Consultation Response from KC, Highways Development Management (HDM)		
2024/91242 Land north east of Shepley Road, Stocksmoor, Huddersfield, HD4 6XW		
Erection of residential development (up to 50 dwellings) with associated access, parking, public open space, landscaping and infrastructure		
Date Responded: 11/04/25	Responding Officer: A.Darwin	Responding Ref: 12-33/18

RECOMMENDATION: HDM are unable to support the development proposals – see conclusion / recommendation at the end of this response.

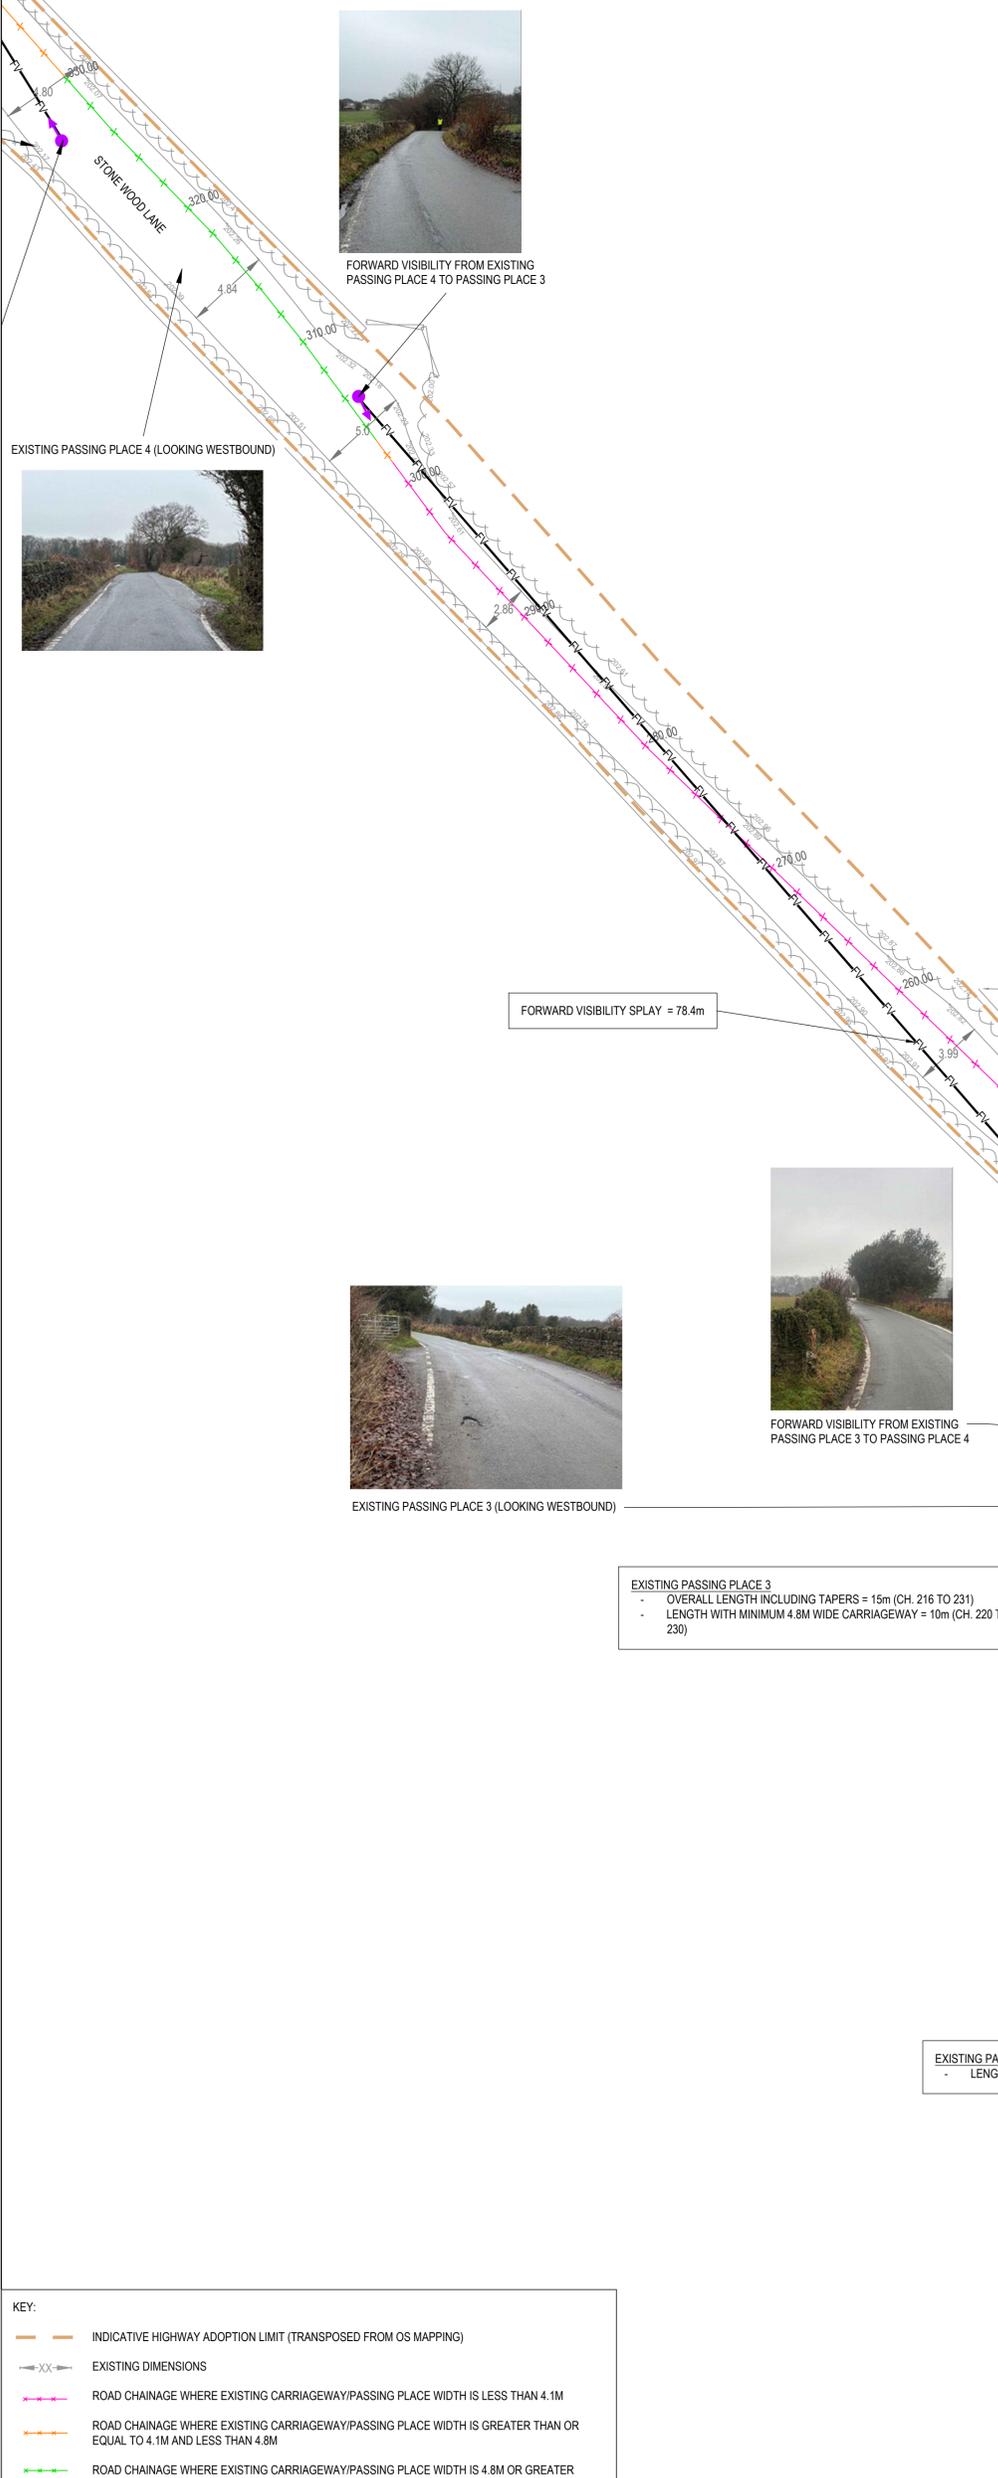
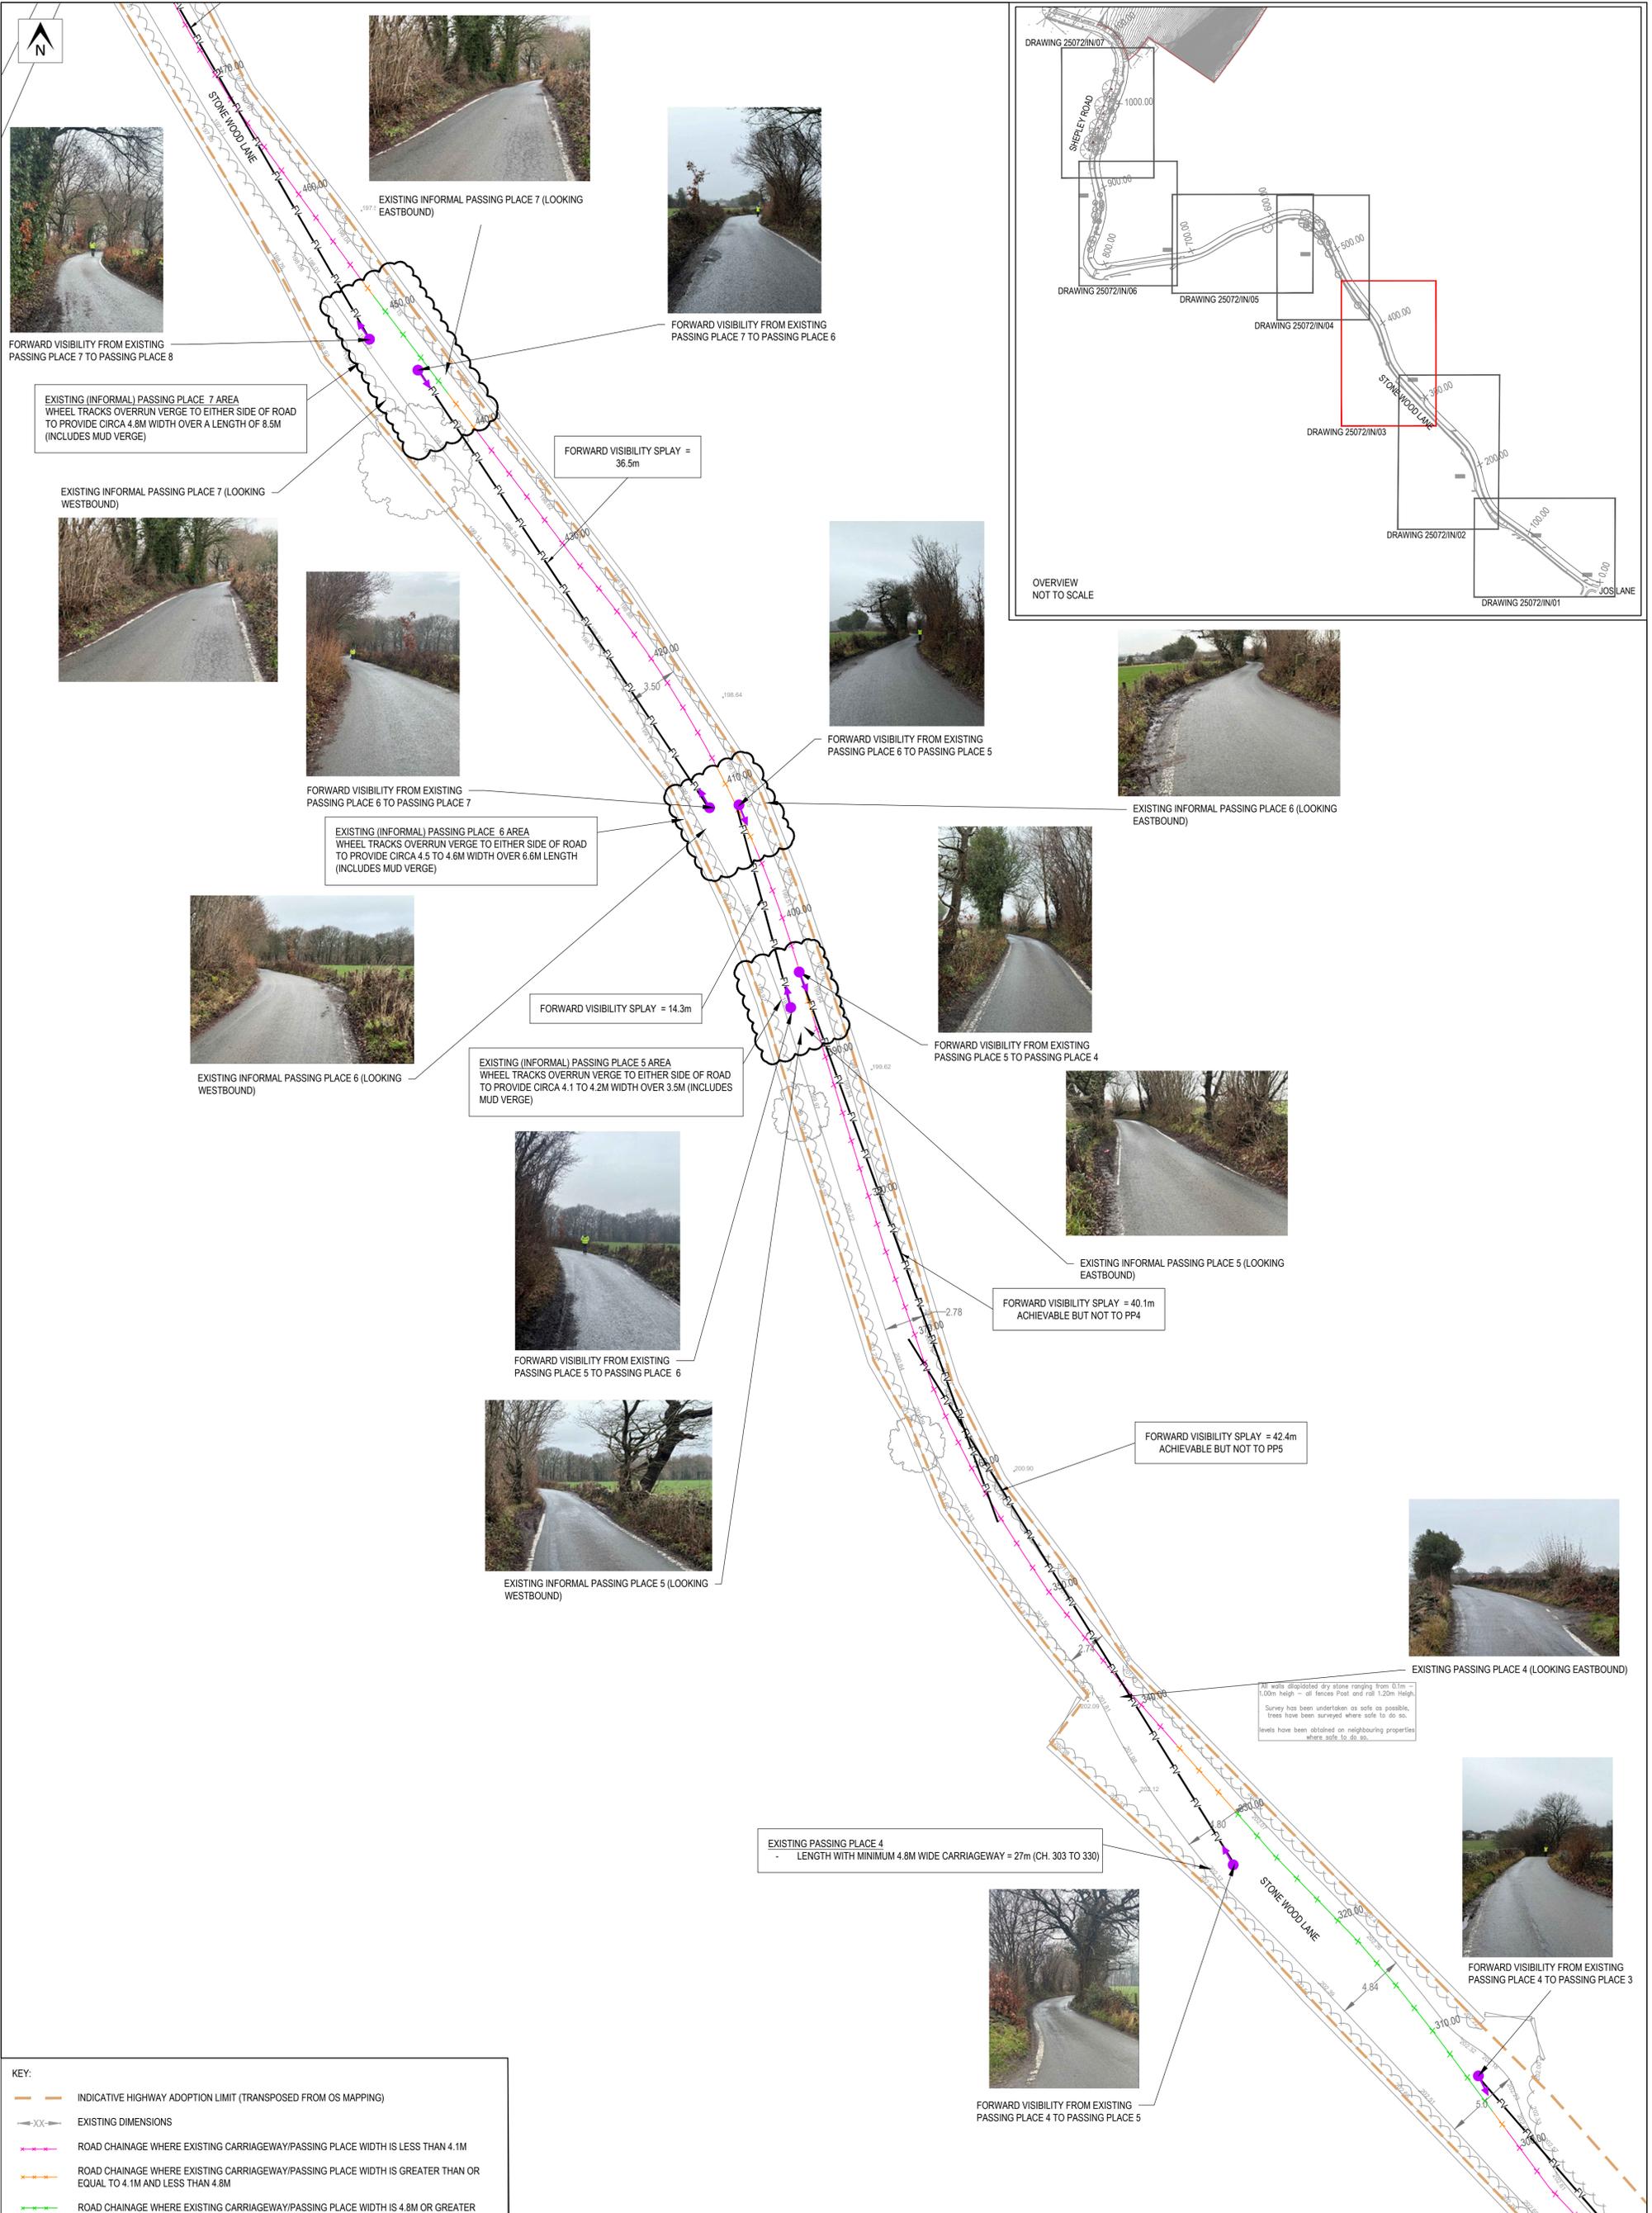
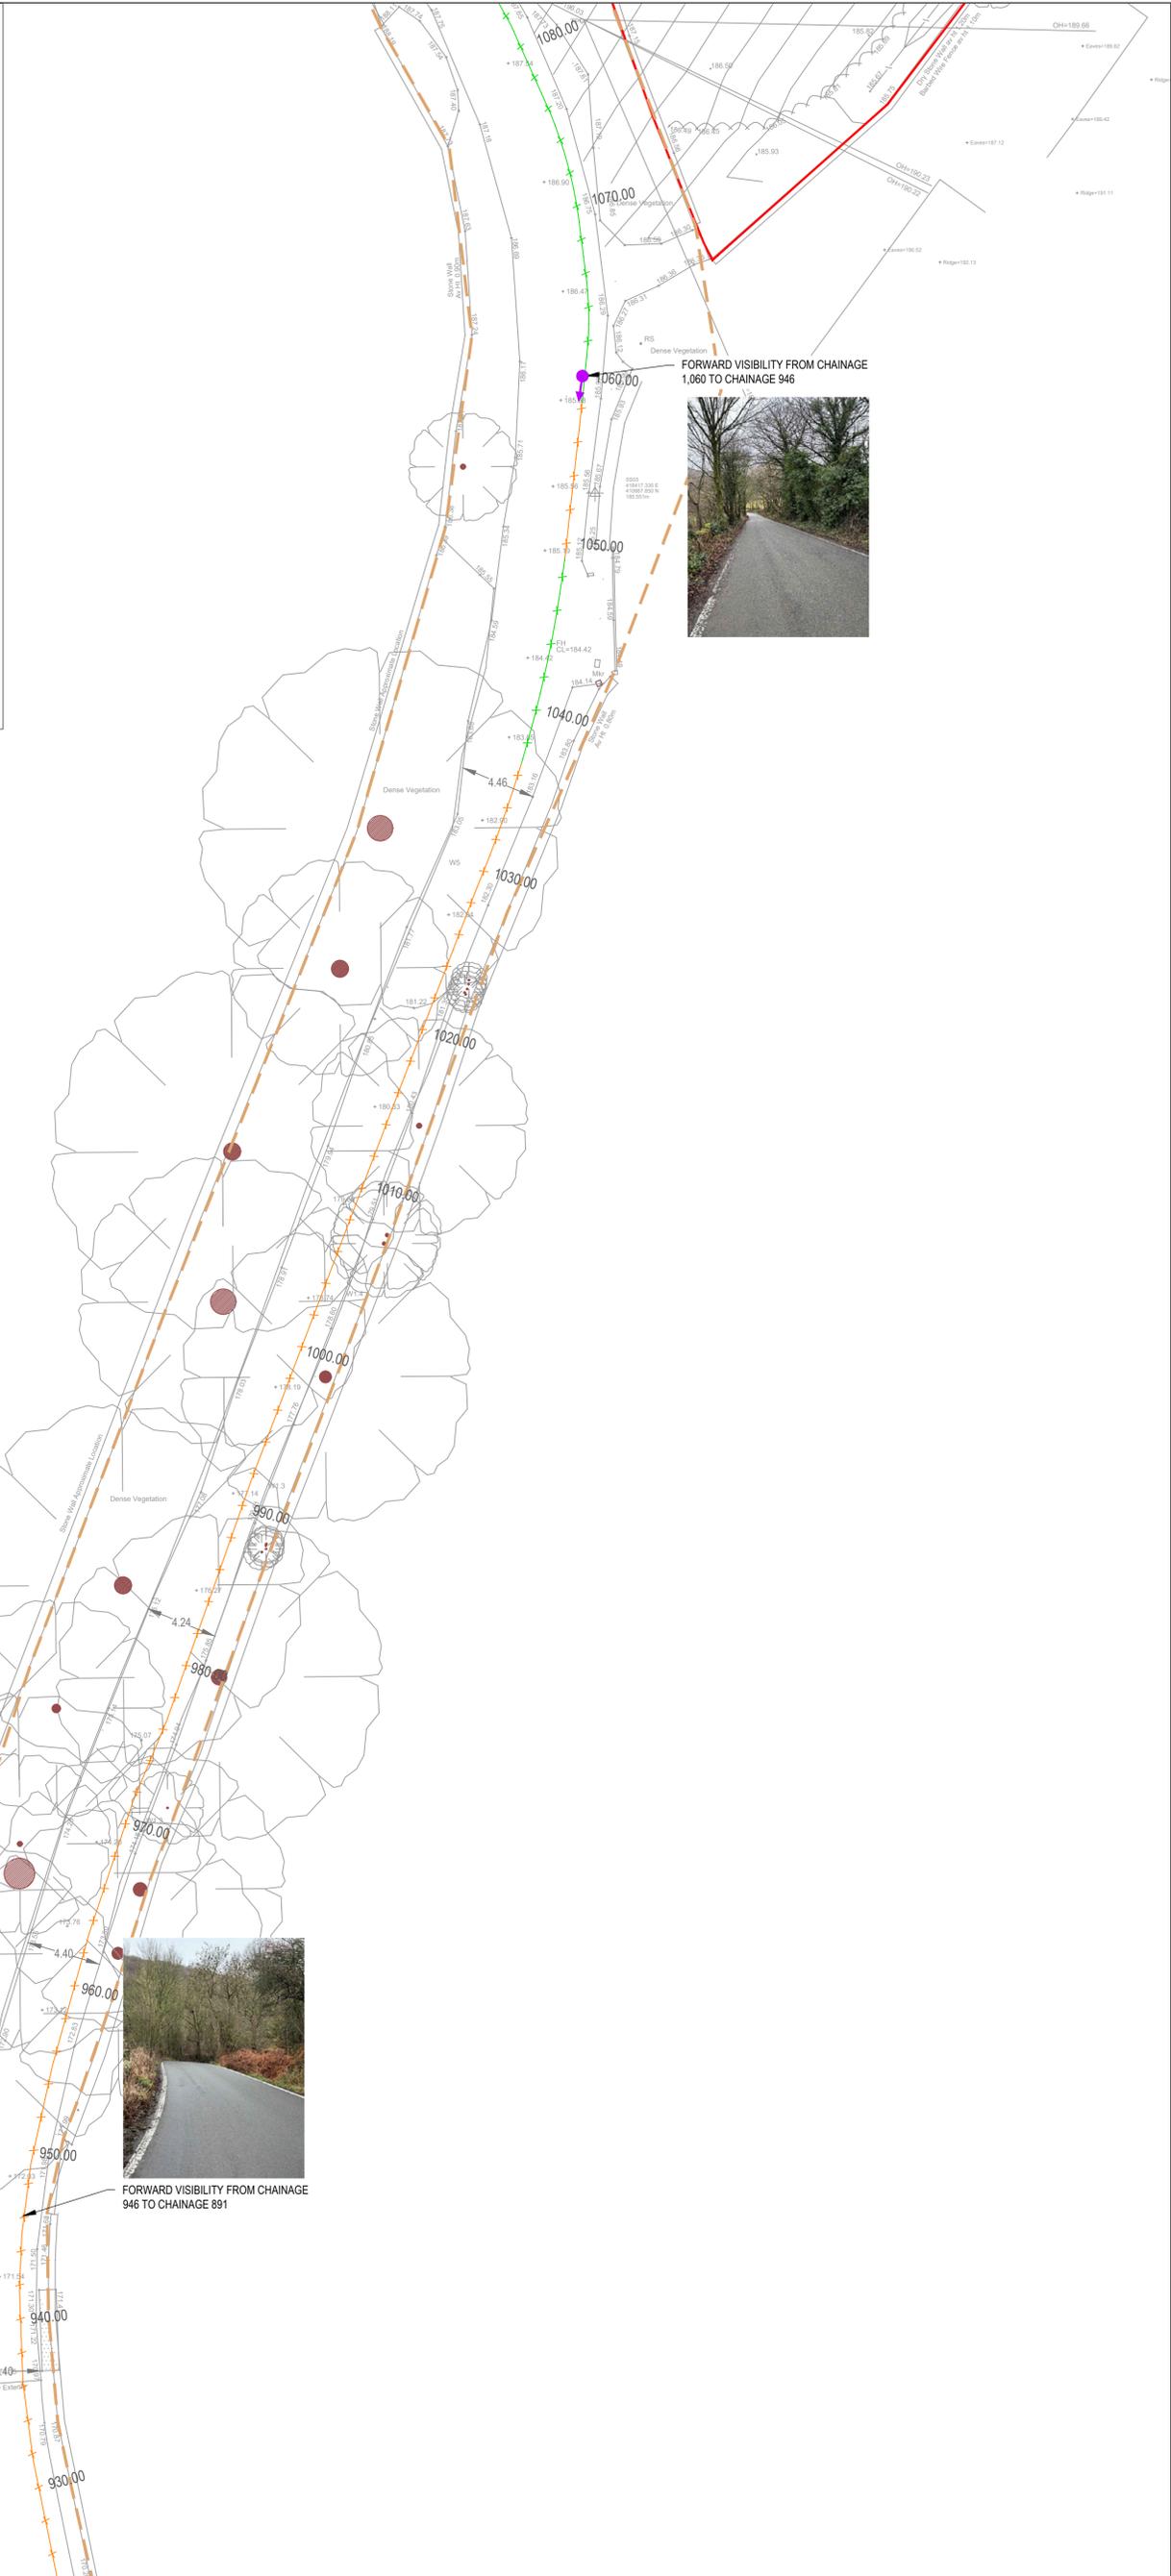
HDM have reviewed these proposed passing place improvements, and accept that they are likely to be the most that can be achieved within the constraints of the highway boundary, along the most constrained / narrow section of Stone Wood Lane. However, whilst these works would provide some improvement over the current arrangements, HDM do not consider that they are adequate to mitigate the impact of additional development traffic, with the passing bay provision still falling well short of the required provision mentioned above. A summary of some of the key issues are as follows:

- All of the passing bay improvements are proposed in locations where passing already takes place, which includes at gate entrances, on verge areas, and in other naturally created passing places (e.g. not hard paved carriageway areas). Therefore, whilst the proposals would provide a better quality carriageway surface at these passing locations, no entirely new passing bays for cars/vans would be created. Therefore, the proposals would not increase the number/frequency of passing place locations.

- The proposals would increase the size of some of the passing places (as well providing an improved carriageway surface). However, some of the passing places could only accommodate 1 vehicle, so may not be effective. Also, some of the passing places are only 4.2m wide, so would be inadequate to enable two cars to pass.
